NORFOLK VANGUARD

Please find attached below a summary of Oulton Parish Council's response at Deadline 9 to the public examination of Norfolk Vanguard. This response was submitted to PINS on 6th June 2019.

Noise Assessment for The Old Railway Gatehouse and OTMP (deadline 8) for Link 68

Figure 1 Proposed road regrading in proximity to the Old Railway Gatehouse

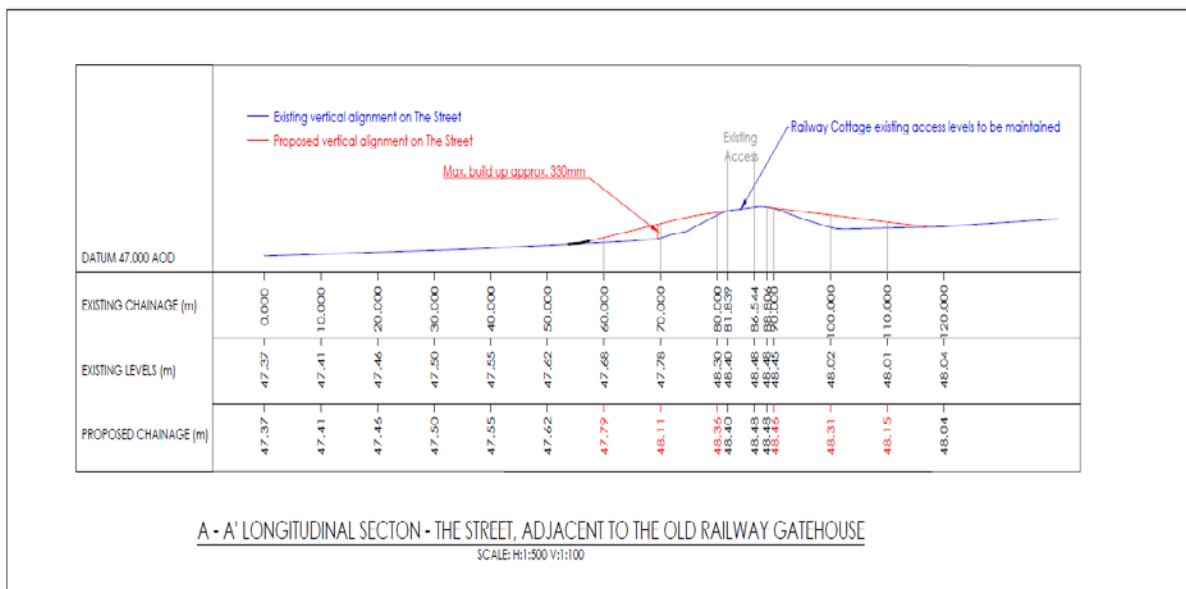
The speeds of traffic measured by HOW3 of 69kh (42mph) - and 96.6kh (60mph) as used by Vattenfall - to form the Noise Assessment are flawed, as the whole of this section of The Street will be subject to a speed restriction of 30mph (imposed by NCC

Both projects have used the reduction in speed as a form of mitigation. OPC have, with both projects, tried to point out that a speed reduction will produce a build-up of vehicles along this route, especially when incorporating HOW3 Abnormal Indivisible Loads (AILs), whose speed will be *below* 30mph. During the delivery of HOW3's AILs (1121 in all) there will be the temporary need to stop traffic movements altogether along The Street, which will further concentrate the flow of traffic afterwards.

Both projects have provided the traffic movement numbers of their construction HGVs and, by proposing the formation of longer passing places to accommodate two HGVs at a time, they presume that this will result in a steady traffic flow. Both projects have only produced a snapshot of baseline traffic over a few weeks by the use of an ATC (Orsted), or by an *estimation* of traffic numbers (Vattenfall). The pattern of additional traffic in the form of agricultural vehicles and other HGVs is an unknown quantity, as this will vary over the course of the year, dependent wholly on where and when a specific harvest takes place, and the time of year. Harvest periods are now longer due to the more varied crops produced. OPC are still of the opinion that both Applicants are persistently failing to understand these important additional traffic factors.
